Our reference: 20/02152/PRE

RE: Worcester Park Former Public Conveniences

PROPOSAL: Demolish the existing Former Public Convenience and construct four bedroom detached house.

The following comments and observations are made in relation to the revised proposals sent to the case officer via email on 12 October 2020.

SHEET TITLE:
Proposed floor plan

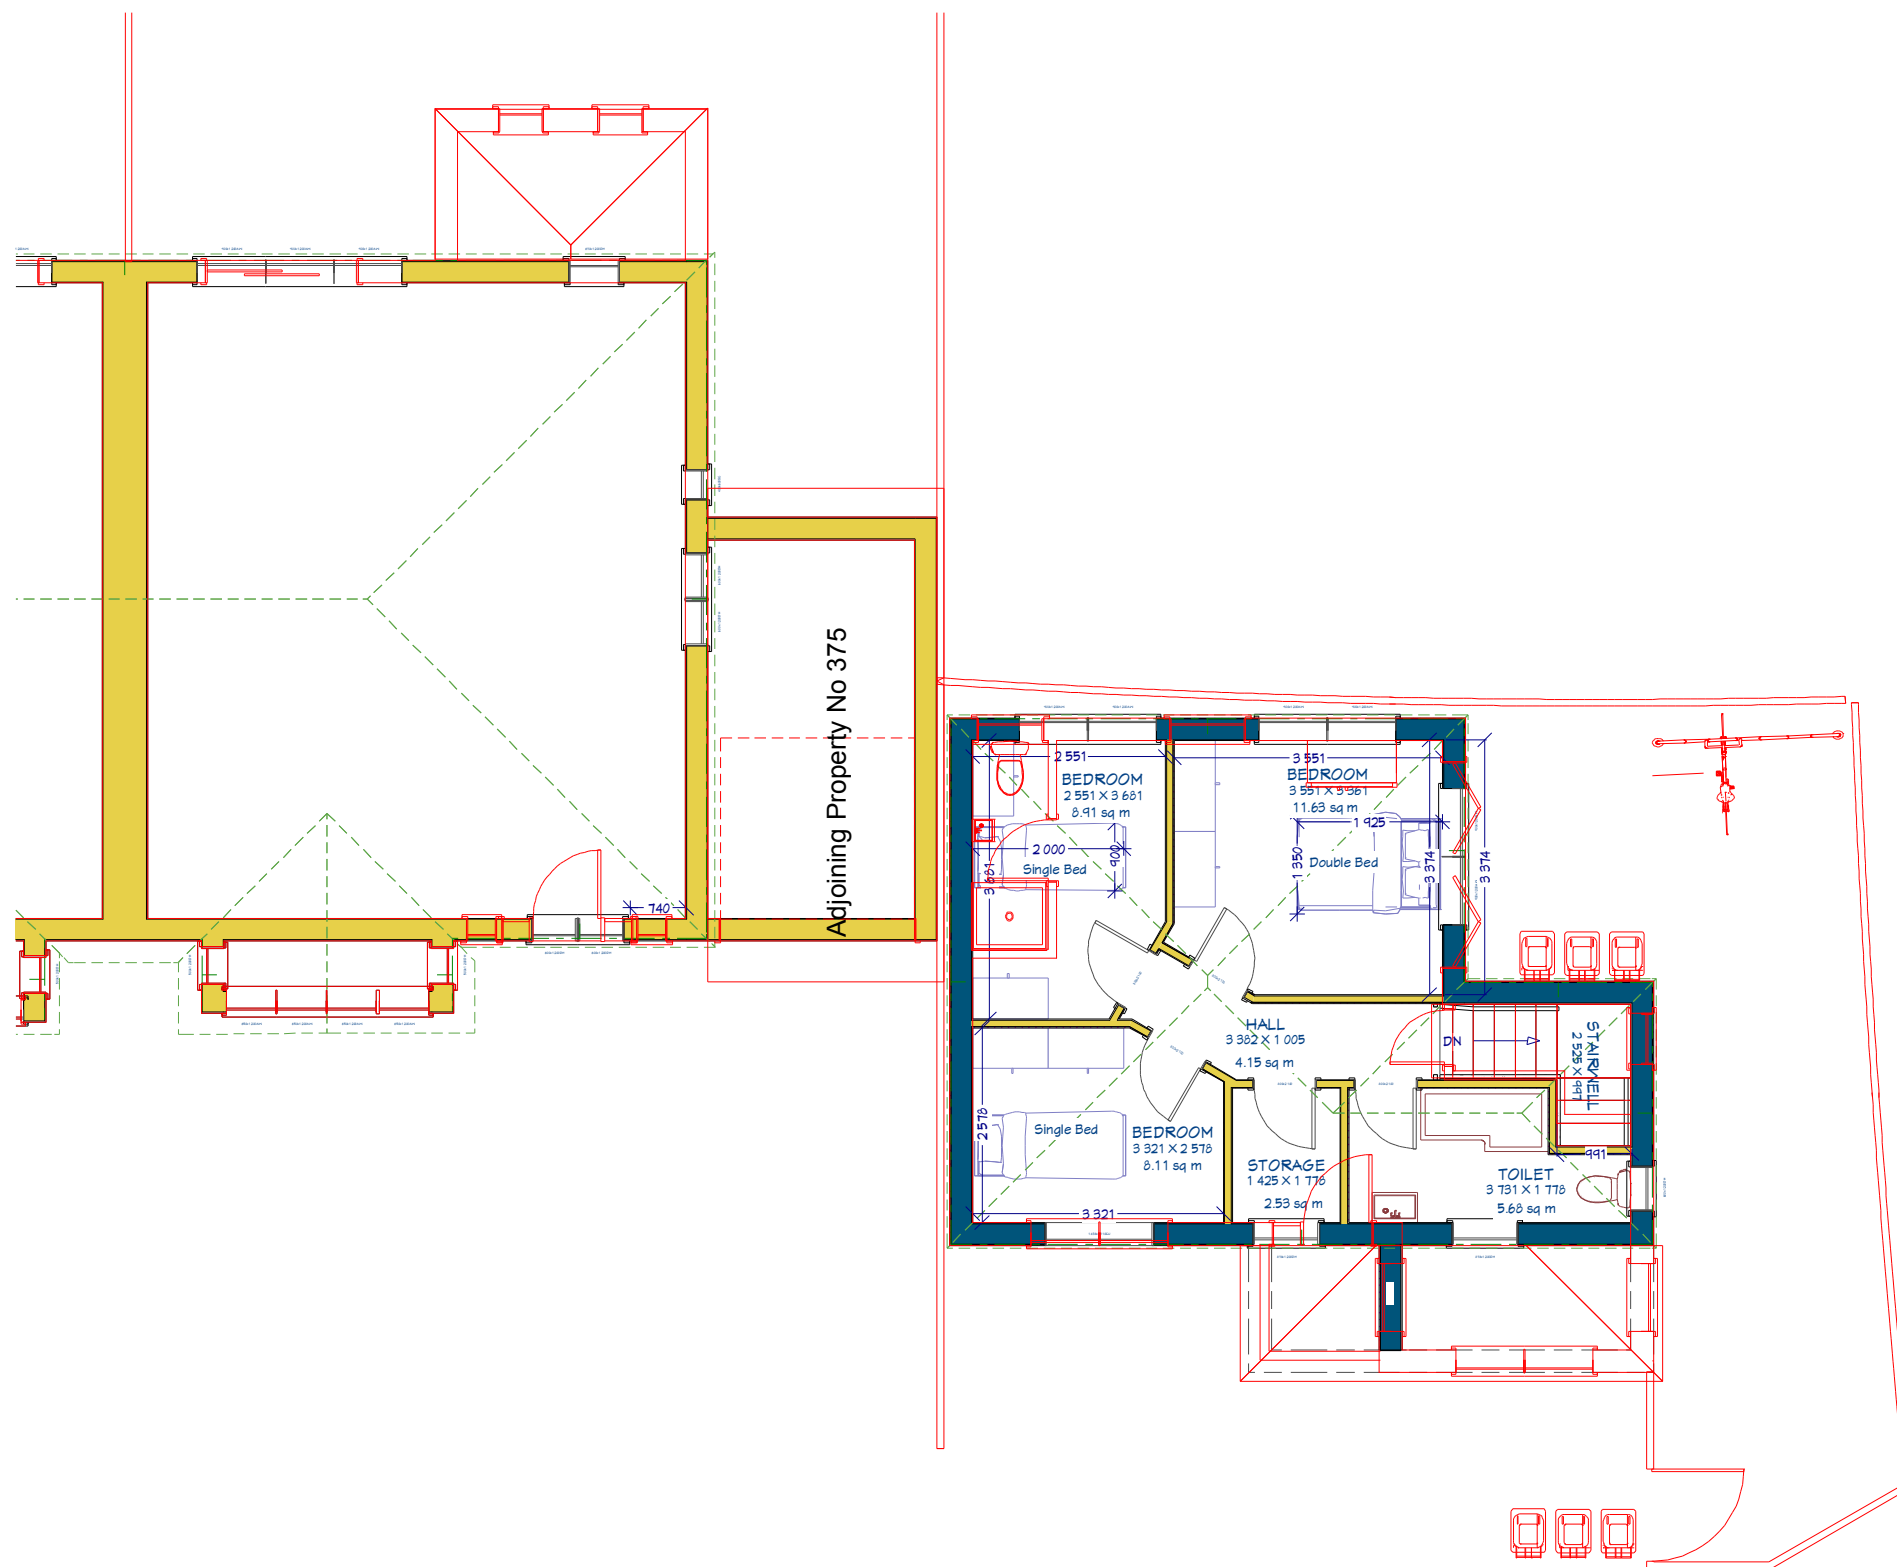
To my mind, the plot is very modest and I am concerned that the provision of a two storey 3 bedroom unit would result in a cramped and contrived form of development. Overall, were a planning application for the pre-application proposal to be submitted, I would be unable to support the proposal. I remain to be convinced that the construction of any substantial building on this piece of land would be acceptable in heritage and townscape terms.

The council applies the London Plan space standards for all new residential development and the proposed scheme would exceed the minimum floorspace requirements for a 3 bedroom, 4 person unit and I would expect any forthcoming proposal to demonstrate that an internal head height of 2.5 metres can be achieved. The unit would be dual aspect which is supported. In terms of access to sunlight/daylight, it would need to be demonstrated that future occupiers would have adequate access to daylight at ground and first floor.

The proposal appears to provide over 50 square metres of amenity space, discounting the car parking area, which complies with the minimum space standard. Although whilst the amenity area would meet the minimum space requirement, the garden area is located to the side of the house and is of an unusual arrangement which is not a feature of the prevailing character of the area. Therefore, any forthcoming application would need to demonstrate that good quality, usable amenity space that is fit for purpose as required by policy guidance 13 of the Council's Residential Design SPD can be delivered.

One off street car parking space is proposed, however, part removal of street furniture, namely the guard rail would be required in order to facilitate a cross over, but more crucially, the crossover would be within 10 metres of a formal pedestrian crossing as well as a junction (vehicular access to the Plough Public House) and therefore is unlikely to be supported by the Local Highway Authority.

Exterior Elevation Right

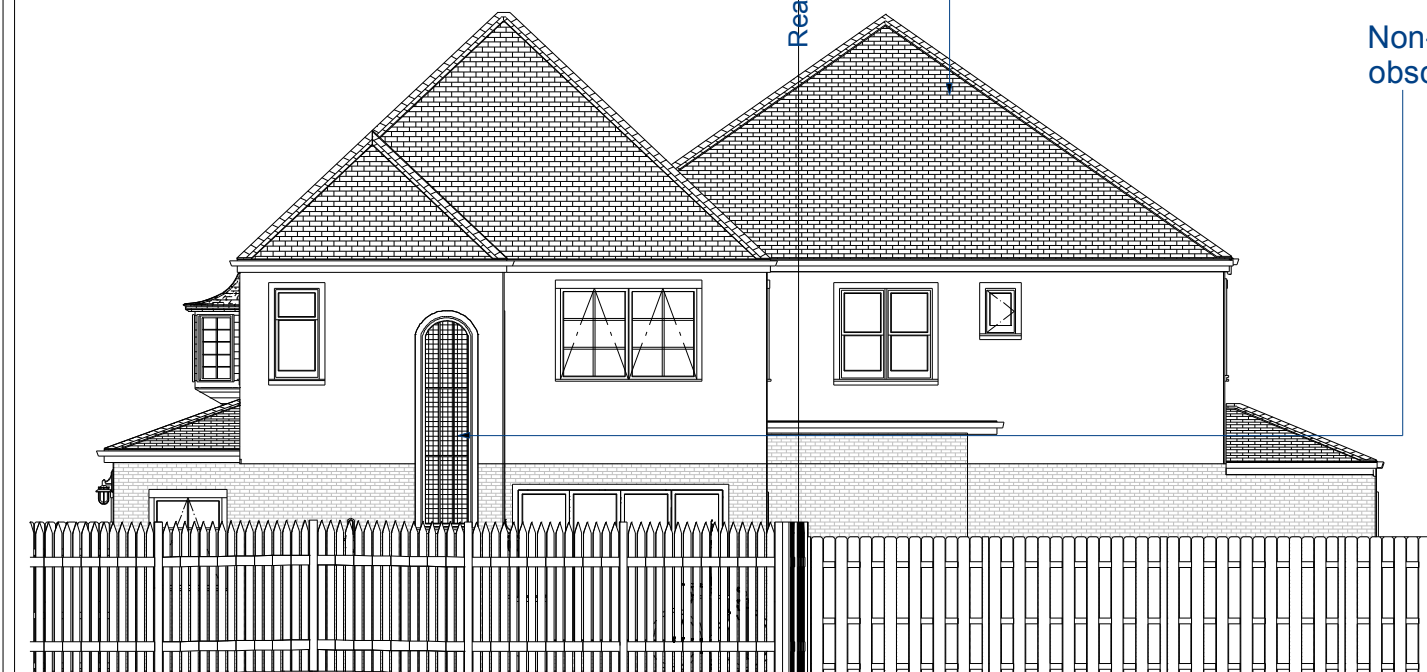
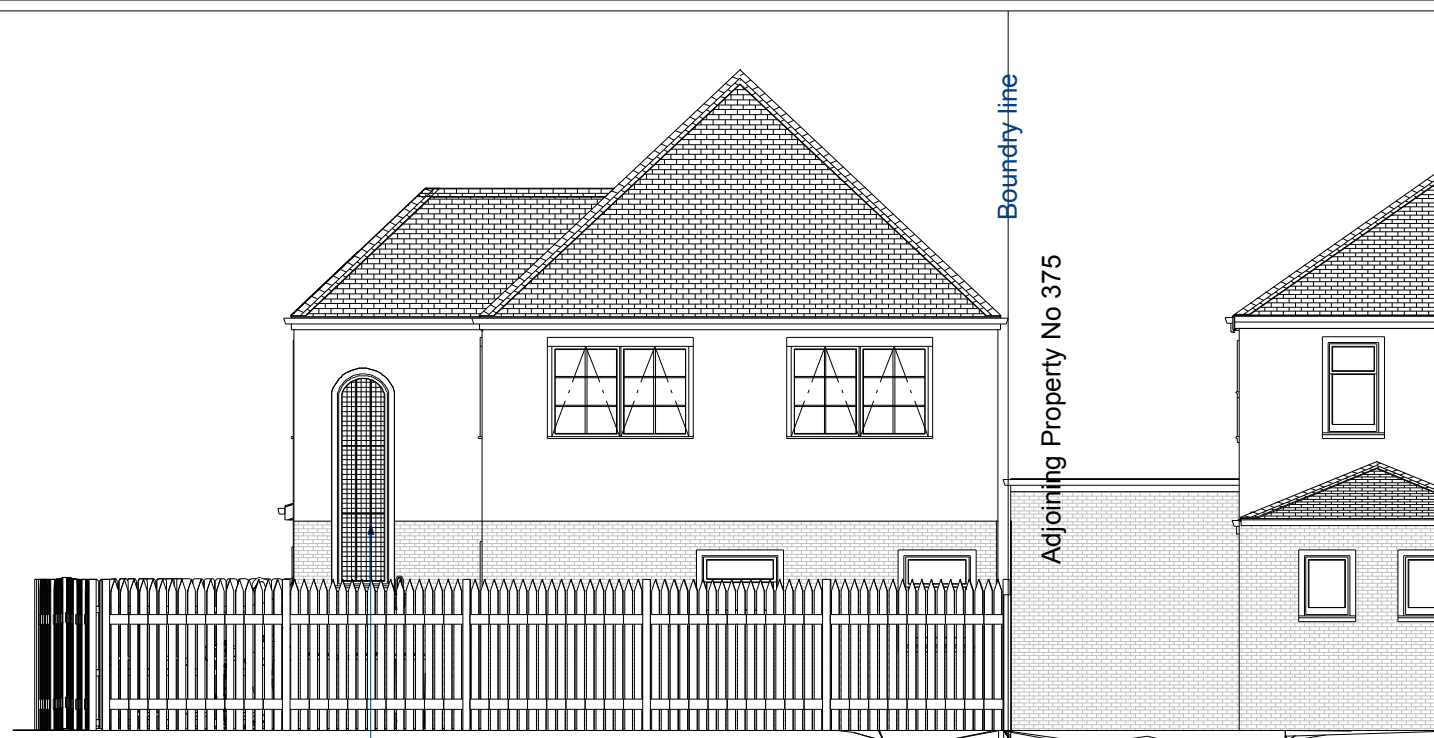
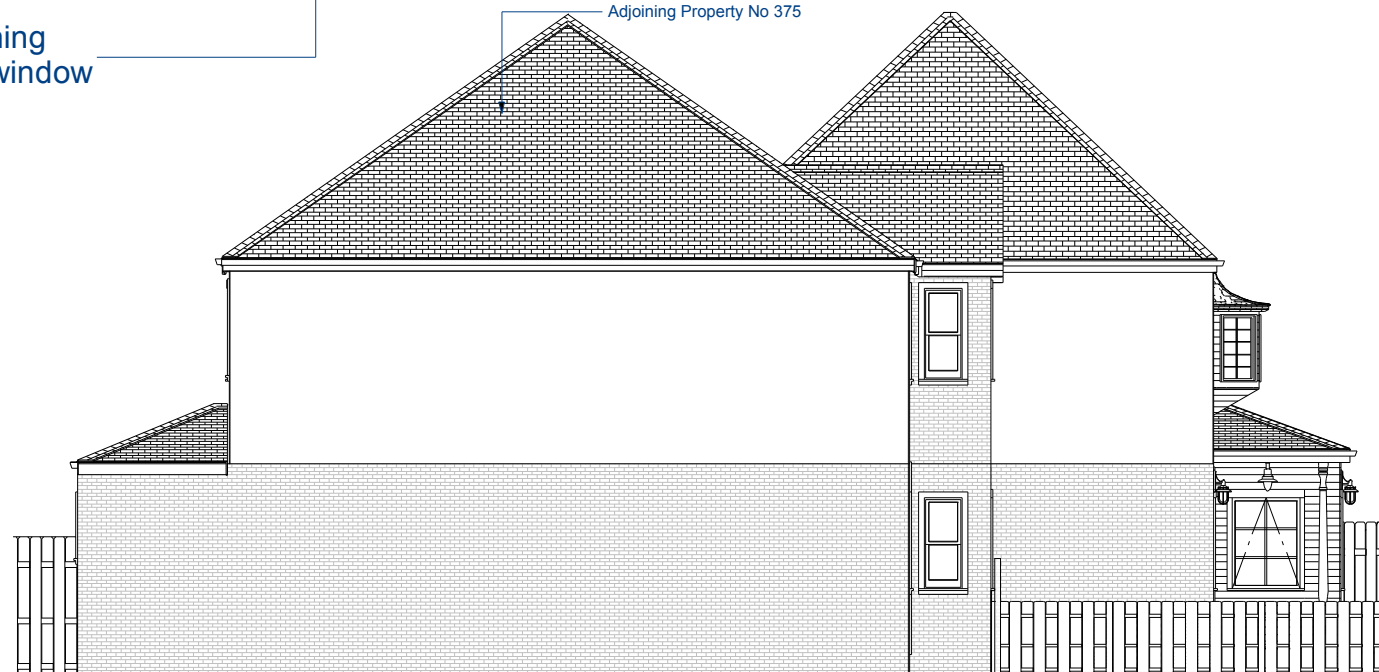
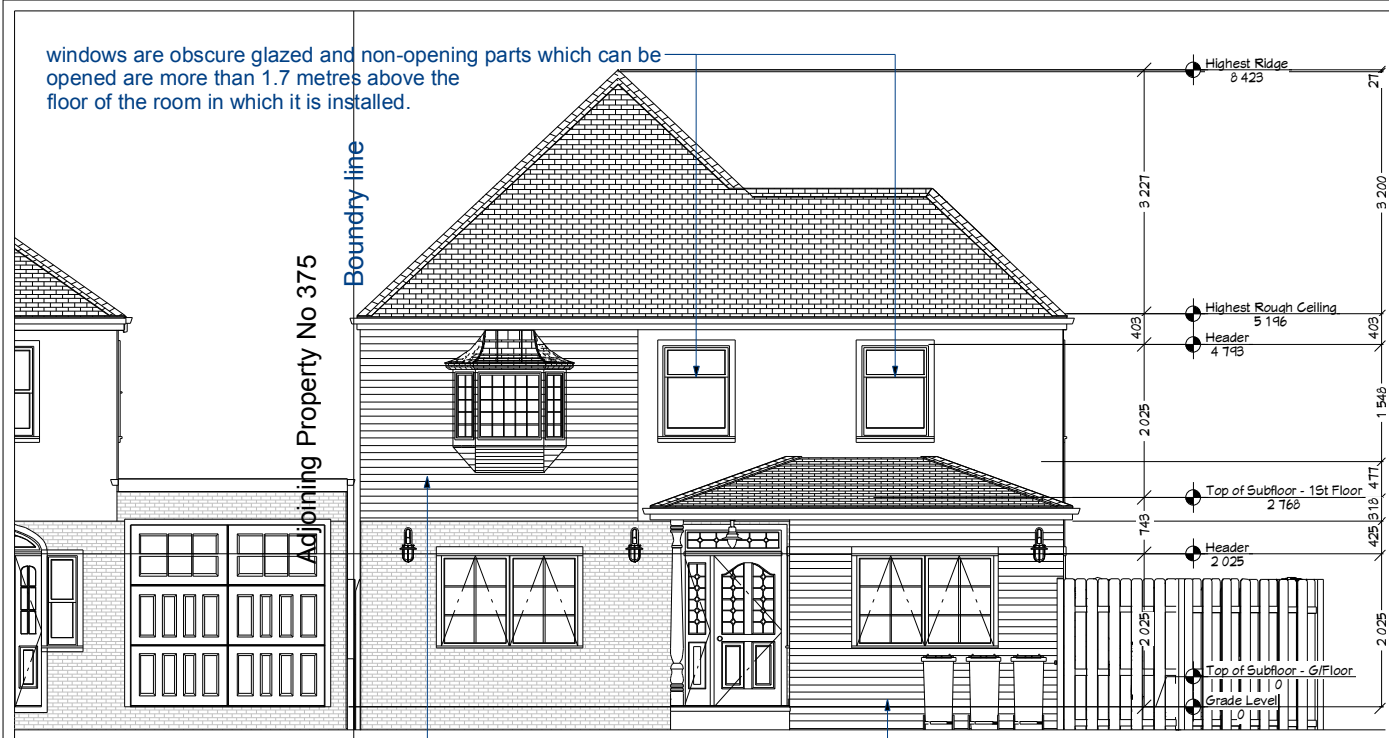
To my mind the proposed scheme would need to respond appropriately to the established building line along Malden Road, whilst ensuring the proposal preserves or enhances the character of the Old Malden Conservation Area and the setting of the Grade II listed Plough Public House. Currently, the two storey house would respond appropriately to the height of the buildings along Malden Road, however, it would sit considerably forward of the established building line which would appear as an incongruous form of development. Furthermore, I recognise that you have conducted some contextual analysis of the surrounding built form including that of the Conservation Area, however, I am not convinced that the design, particularly the roof form, is an appropriate response to the Old Malden Conservation area within which it would be located, nor preserve the setting of the listed building. During our discussions it has been recommended that you consider consulting a heritage consultant to inform the design approach of any future submission which remains my advice.

No windows facing No. 375 Malden Road are proposed and therefore the proposal is unlikely to have an adverse impact on the amenity of the occupiers of this dwelling in regard to privacy.
